**Ann Machado - Re: New Single family home at 760 Ocean Ave. #2013-00897**

I have completed my zoning review of your application to build anew single family home and detached garage at 760 Ocean Ave.

PROPOSED EXTERIOR ELEVATION
NORTH AND SOUTH

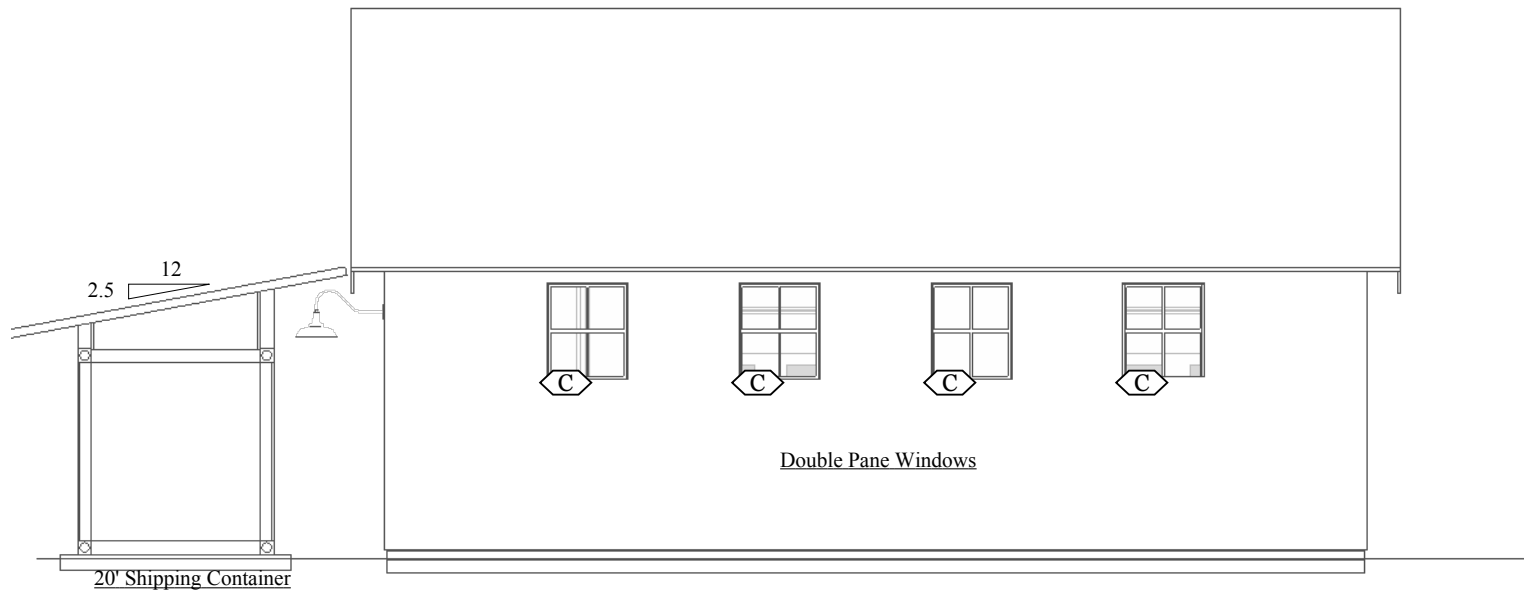
1. The detached garage cannot be higher than 18'. The height is measured midway between the level of the eaves and the highest point of the pitched roof. Since you did not include a graphic scale, I need to know exactly what the height is at the mid point and I need confirmation that the garage will not be higher than 18'.
2. In the submitted documents, the one titled "Written Description of Existing and Proposed Easements or Other Burdens", #2 is a proposed easement to CMP to set and maintain one pole etc. Is this easement shown on the site plan? Is it being recorded?

1. Based on your concern I looked at the design file for the garage. On the plans I mistakenly gave the roof peak elevation to the truss structure where the highest point of the pitch roof is required. As a result of the roof system, the highest point is 23' - 7 1/2". I will lower the peak by no less than 7 1/2" through an adjustment of the roof pitch to comply with a maximum garage height of no more than 18'.
